Appeal Decision

Appeal Ref: APP/R5510/D/23/3329085

Blueberry Lodge, 24 Aspen Grove, Eastcote, Hillingdon HA5 2NL

- The appeal is made under section 78 of the Town and Country Planning Act 1990 against a refusal to grant planning permission.
- The appeal is made by Dr Manoj Patel against the decision of the Council of the London Borough of Hillingdon.
- The application Ref 76928/APP/2023/1183.
- The development proposed is erection of single storey front porch and loft conversion with three front dormers.

DRAWING TITLE: EXISTING/PROPOSED ELEVATIONS

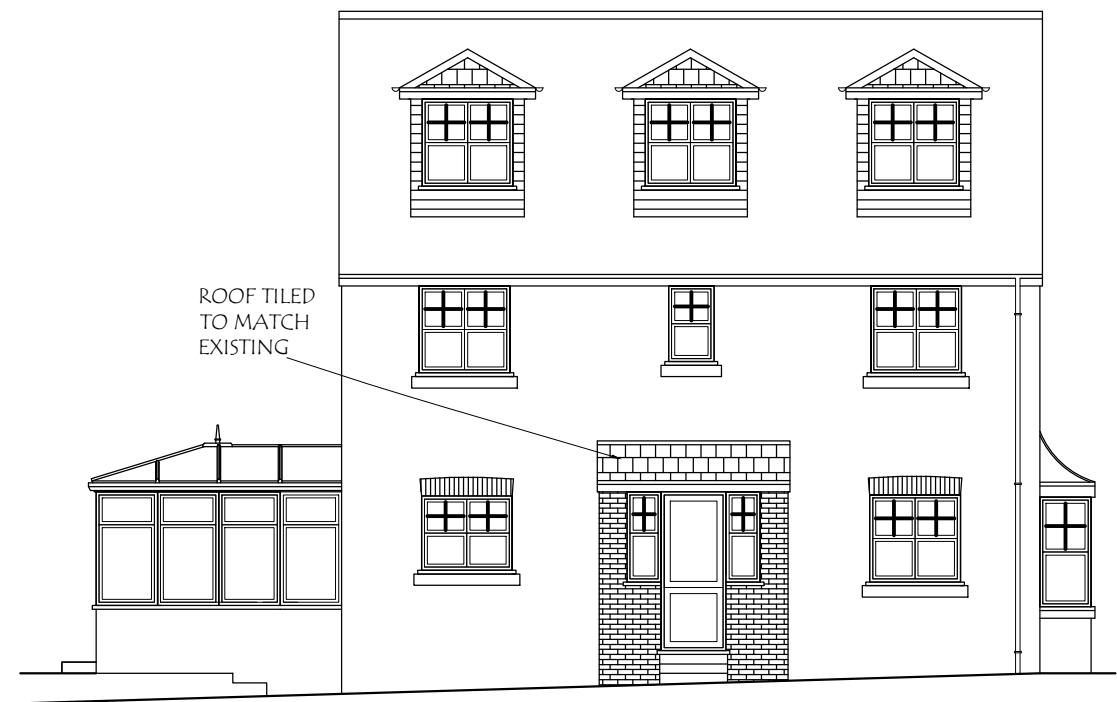
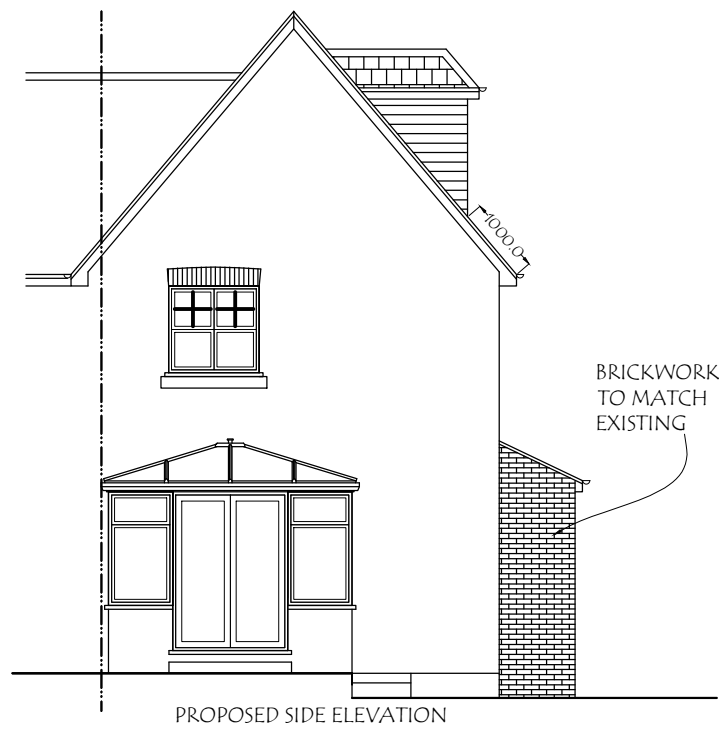
6. Policy DMDH 1 Criterion E of the London Borough of Hillingdon Local Plan Part 2 – Development Management Policies (2020) (Local Plan Part 2) relates to roof extensions. Amongst its provisions, the policy states that roof extensions should be located on the rear elevation only and subservient to the scale of the existing roof. The proposed dormers would be positioned to the front and they would therefore conflict with this element of the policy.

7. The roof of No 24 is an integral part of the street-facing roofscape within the development, which is predominantly characterised by dwellings of simple forms with plain roof slopes. Even though the proposed dormers would be aligned with the existing fenestration below, they would appear wider than the majority of the windows within the main body of the dwelling and significantly wider than the central window within the upper floor. Due to their height and bulk the dormers would appear as discordant additions to this prominent roof slope.
